From: David Innes
Sent: 10 July 2017 15:42
To: Planning.Responses
Subject: FW: Land at New Road, Rustington, Littlehampton - A/11/17/OUT

From: Paul McLaughlin [REDACTED]
Sent: 10 July 2017 14:02
To: 'Dominic Smith'
Cc: 'James Marshall'; 'Edward Ledwidge'; David Innes; 'Hugh Dennis'; Paul McLaughlin
Subject: RE: Land at New Road, Rustington, Littlehampton - A/11/17/OUT

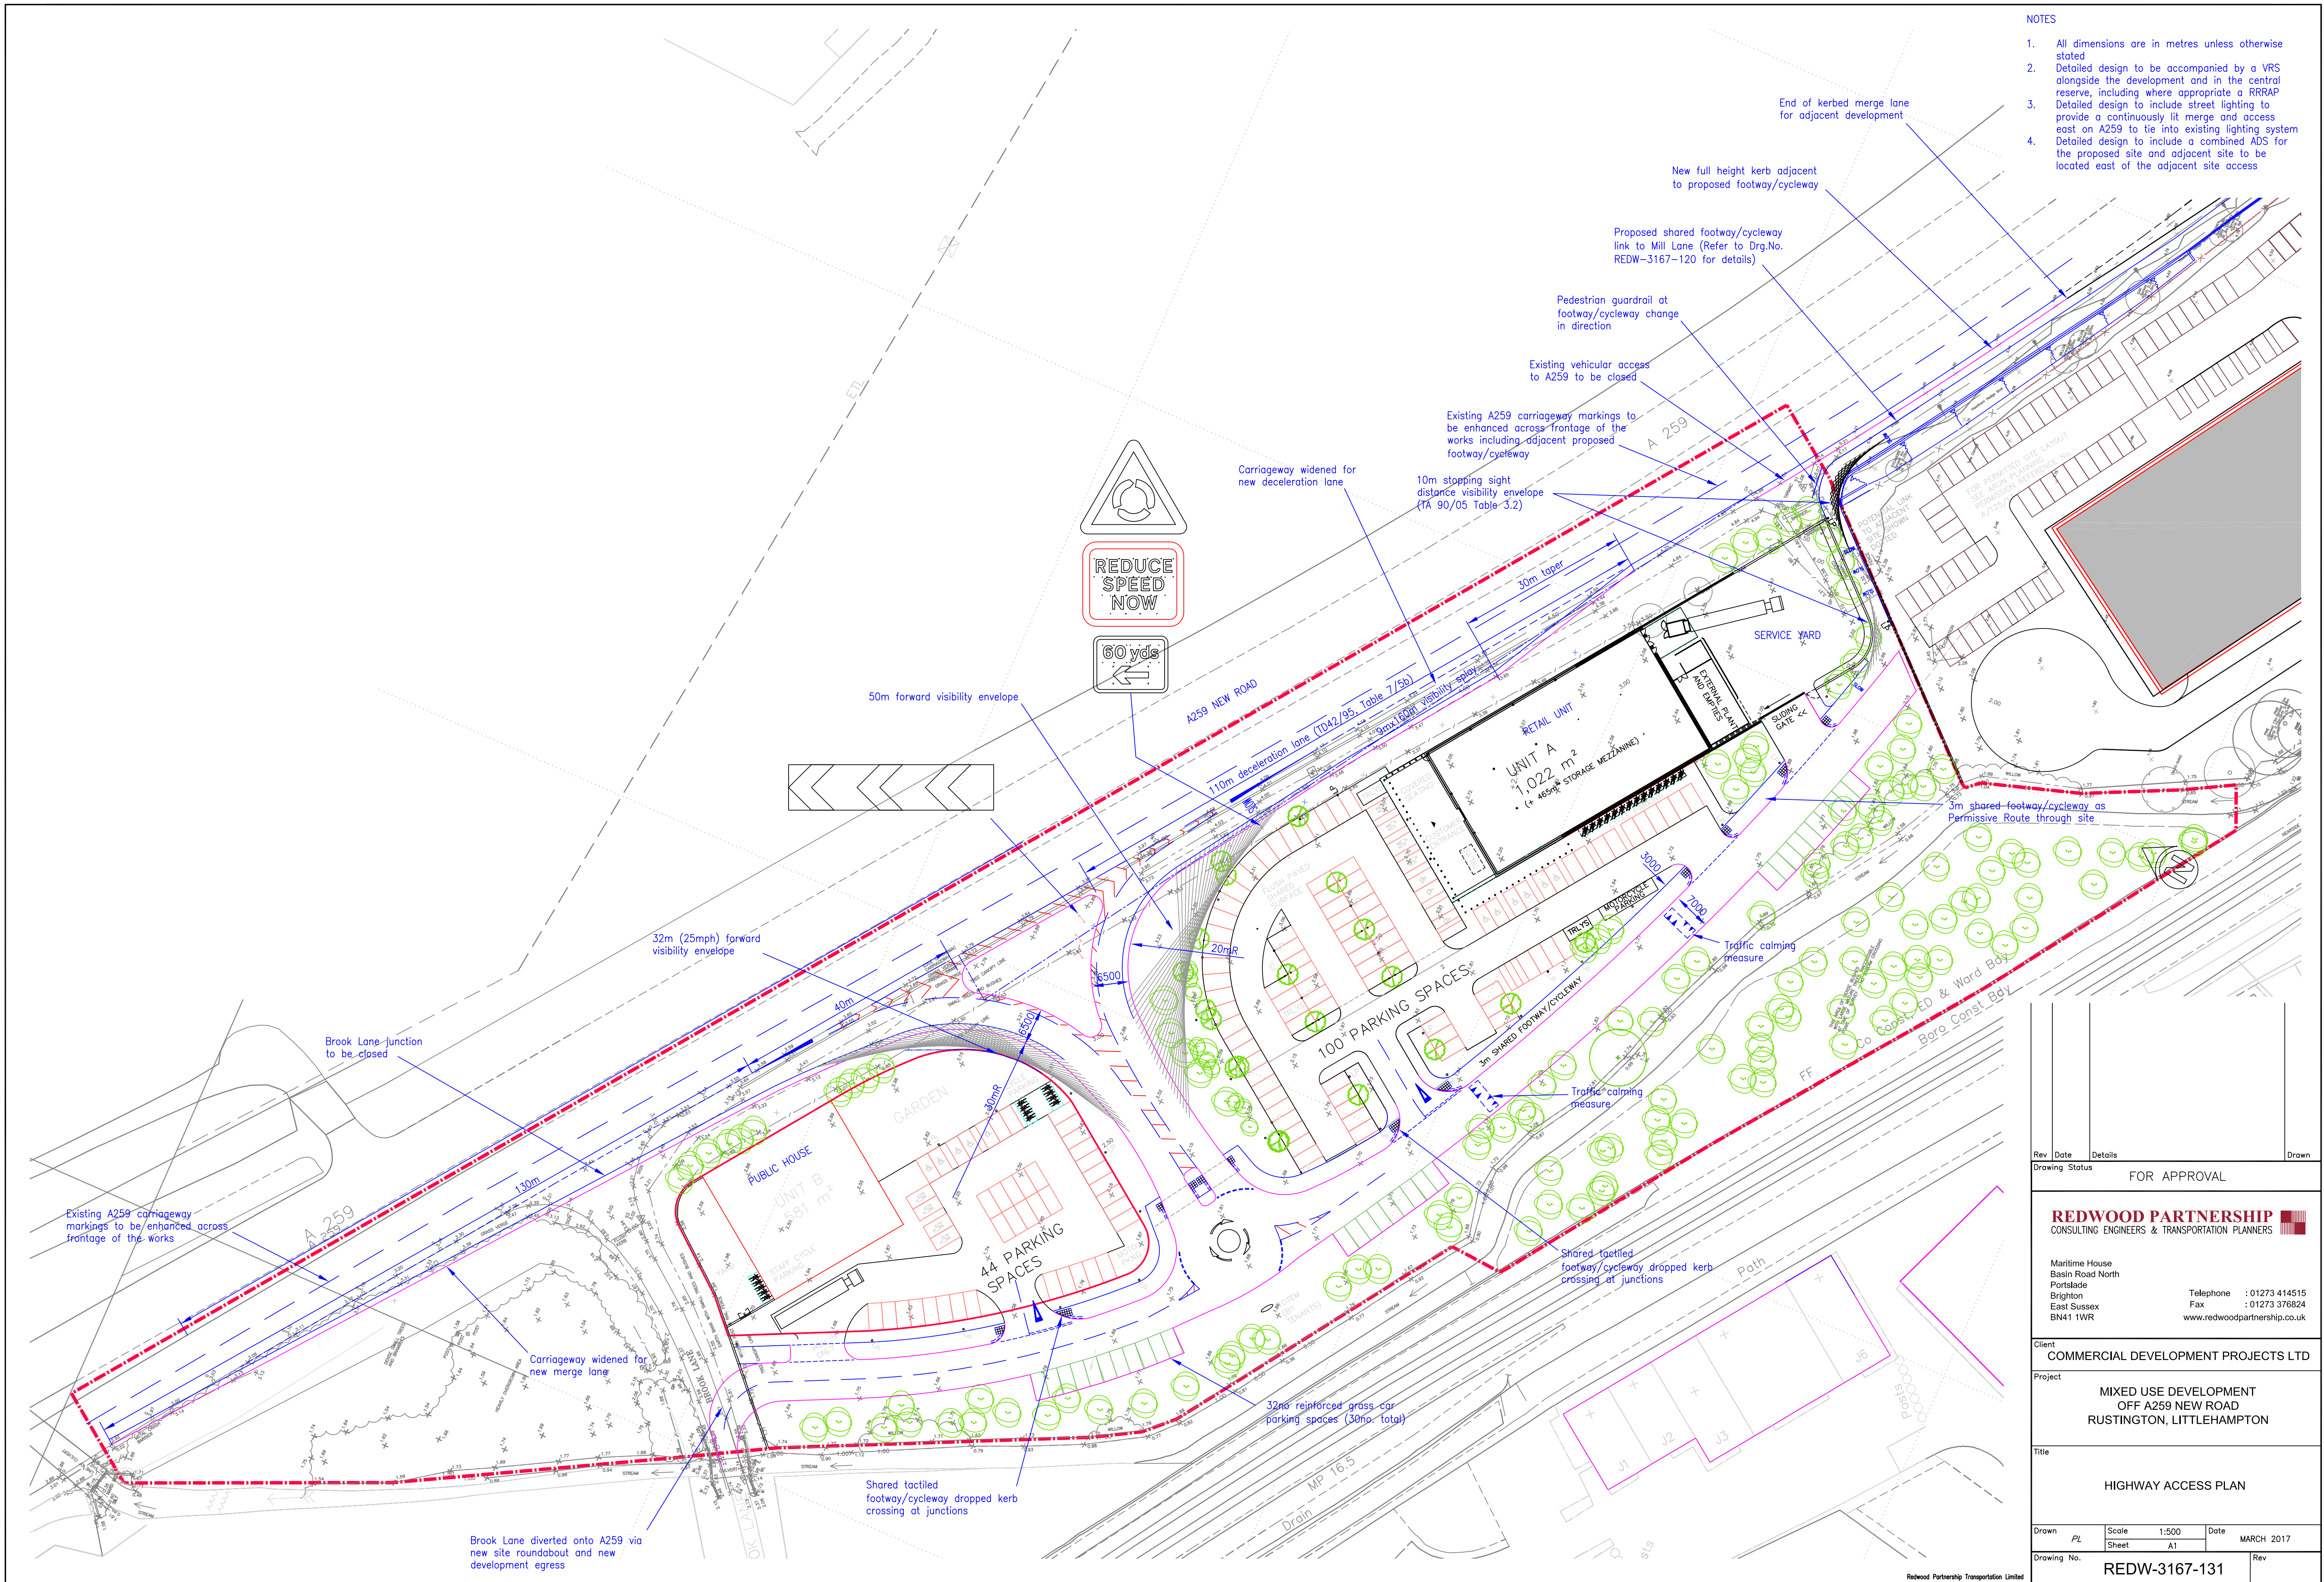
1. Drawing No. REDW-3167-120A
 - i) The cycle lane shown on Mill Lane does not form part of our works and was installed as part of the adjacent car sales showroom planning permission. It has now been installed and is therefore part of the existing road markings
2. Drawing No. REDW-3167-131
 - i) Tactile amended
 - ii) Hatching amended
 - iii) We have amended the layout to set back the cycle crossing at least 5m behind the give way

We enclose amended drawing REDW-3167-131-A showing alterations

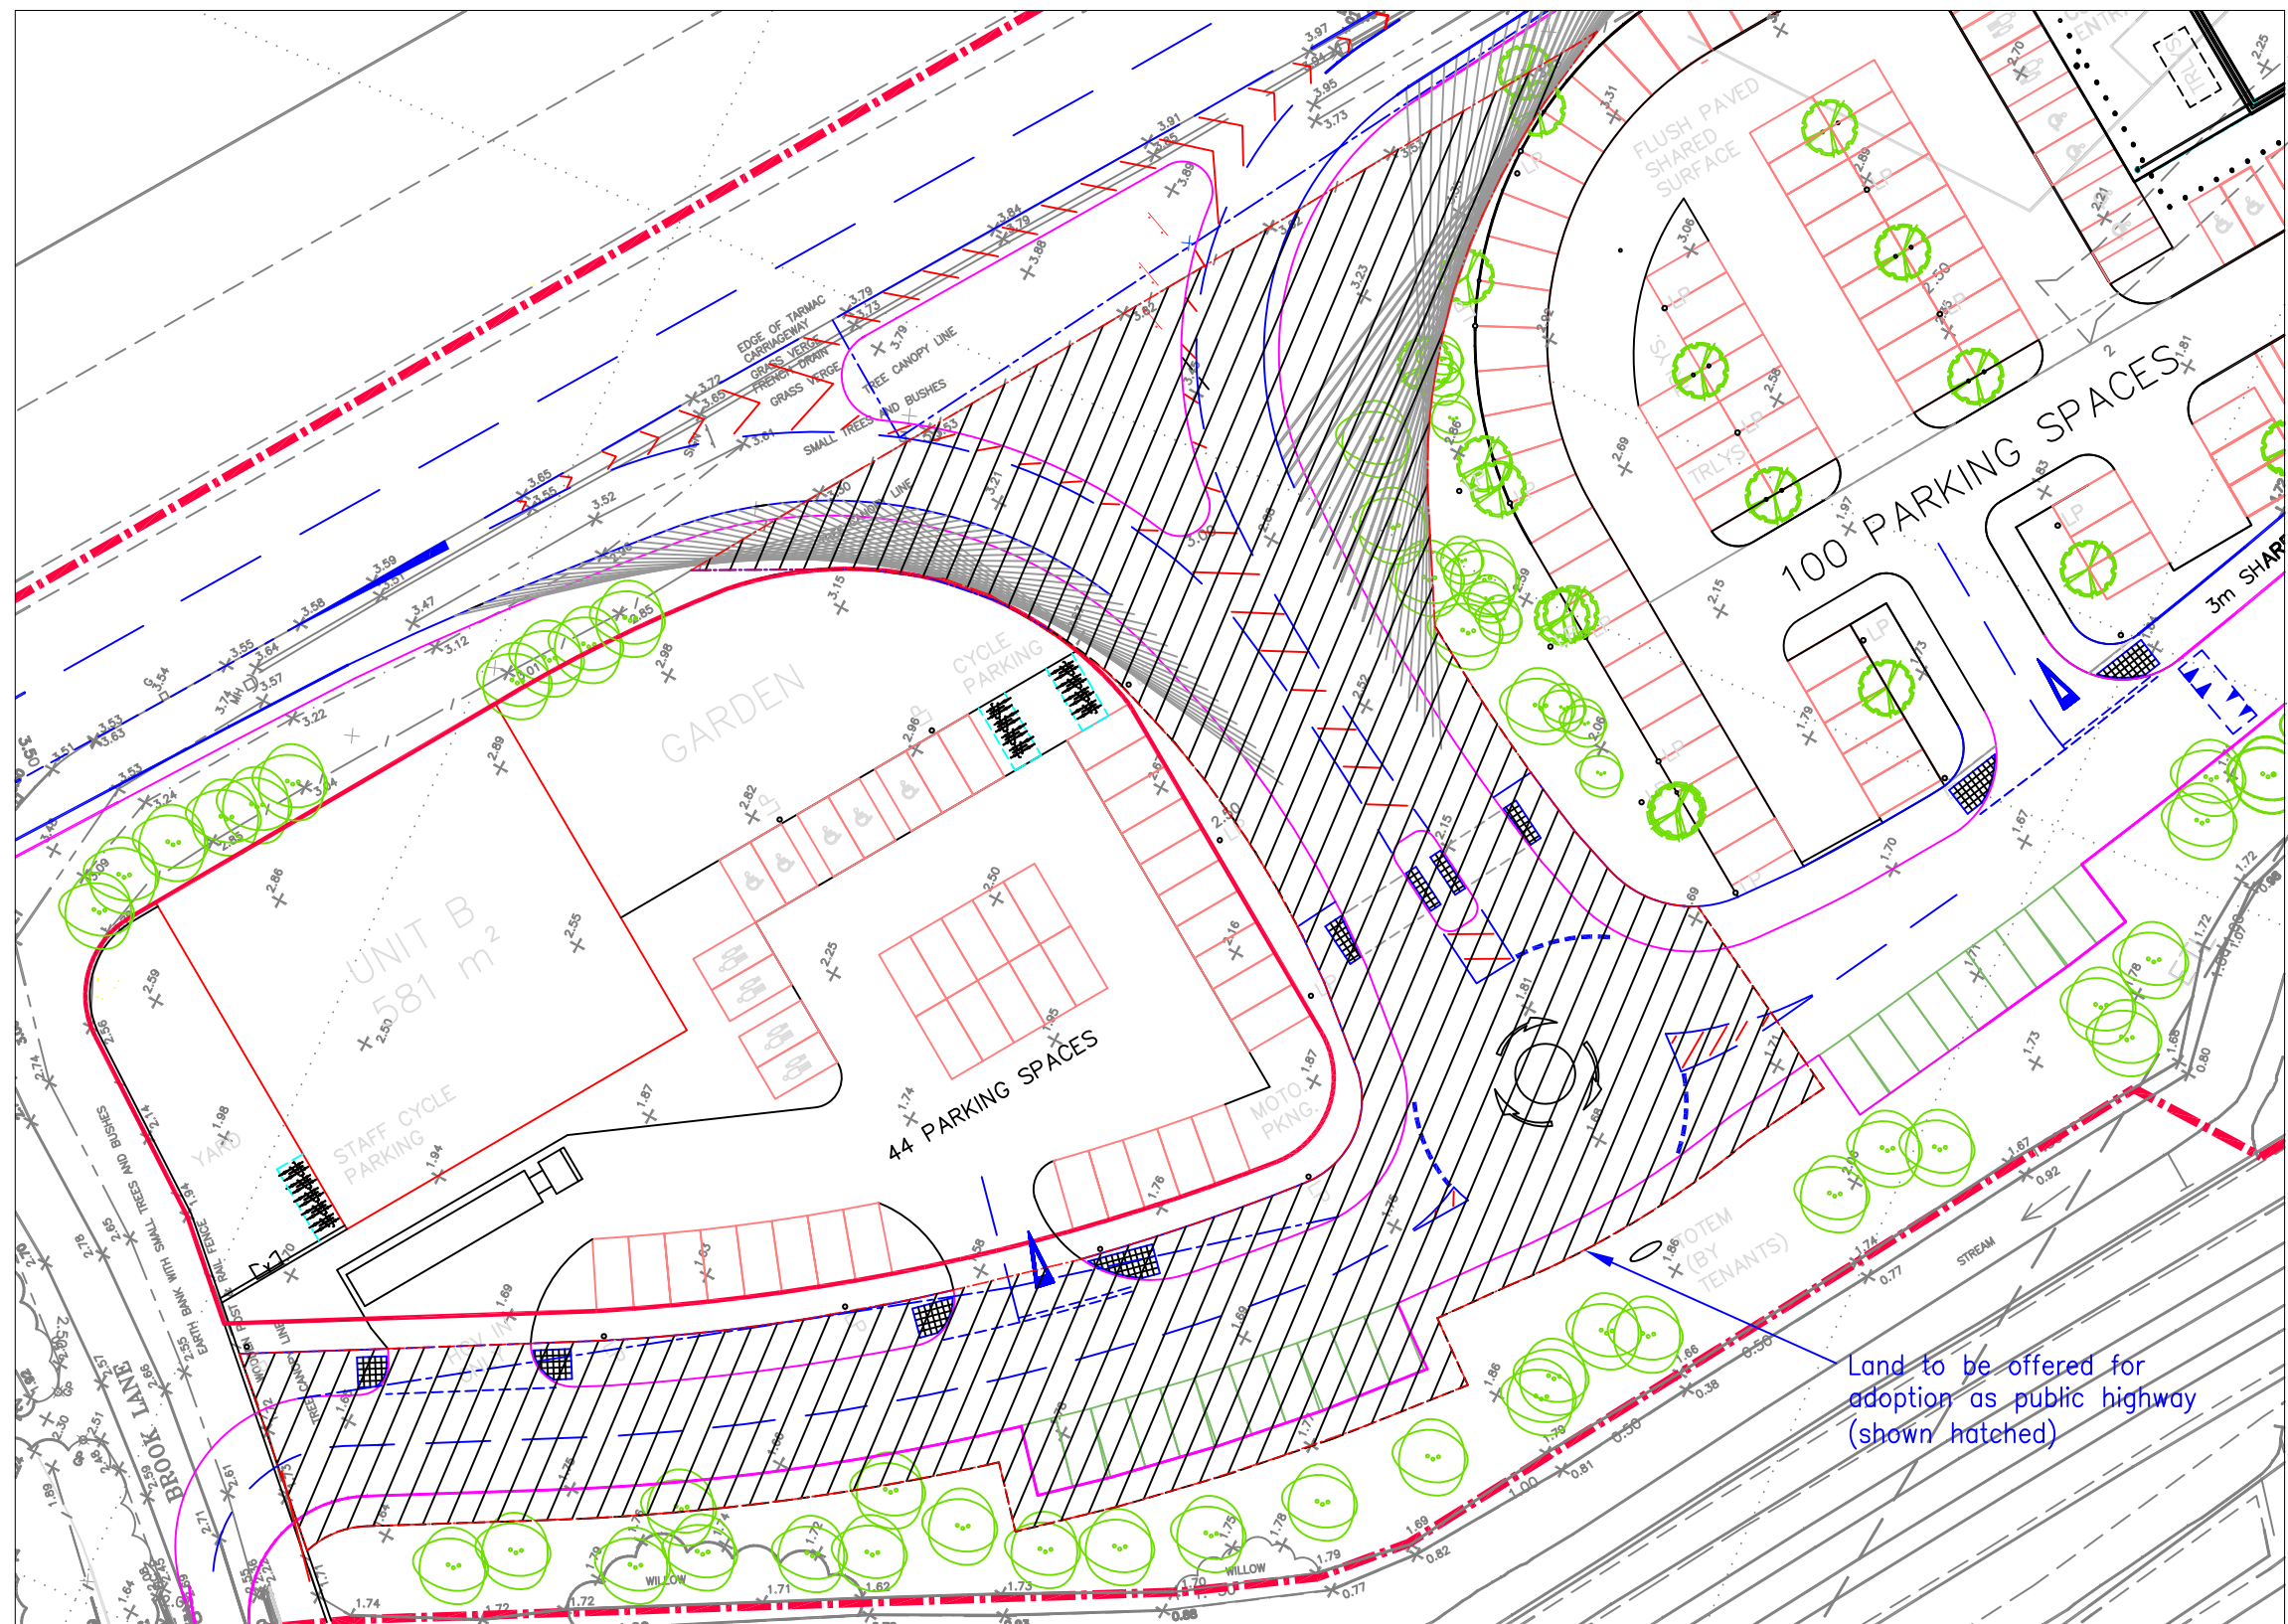
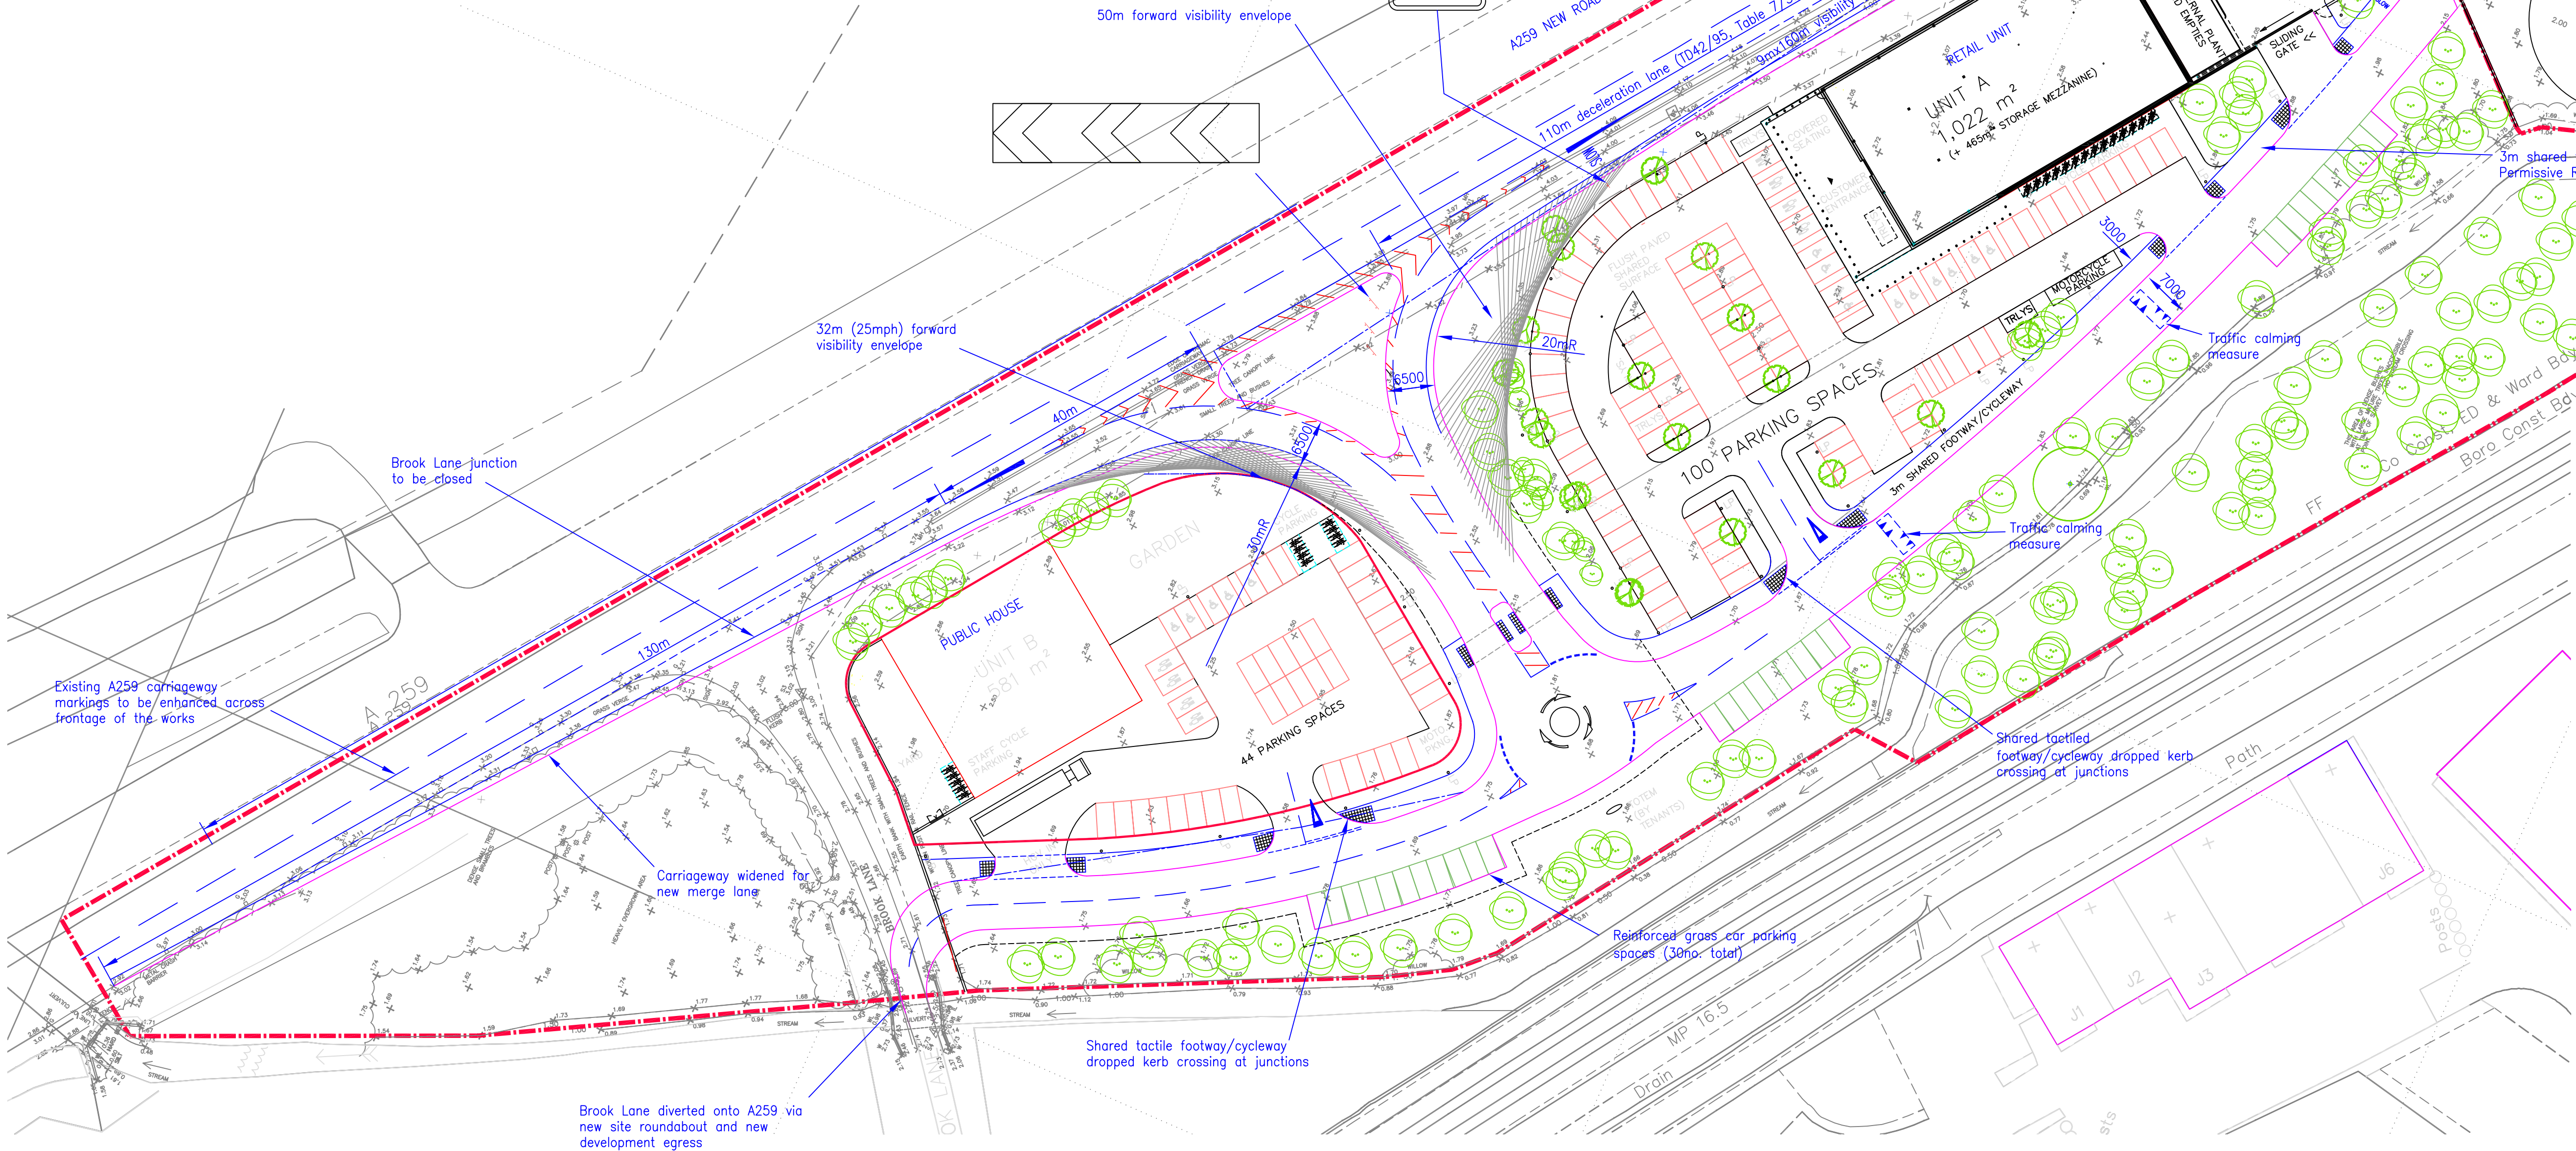
We would be looking to offer for adoption as public highway the site access, mini roundabout and access south of the public house to the western boundary of the site (see attached plan REDW-3167-131-A). This would allow the adjacent housing scheme to connect through this site to the A259. Please can the principle of the adoption be agreed. Our attached plan shows the land to be adopted as hatched
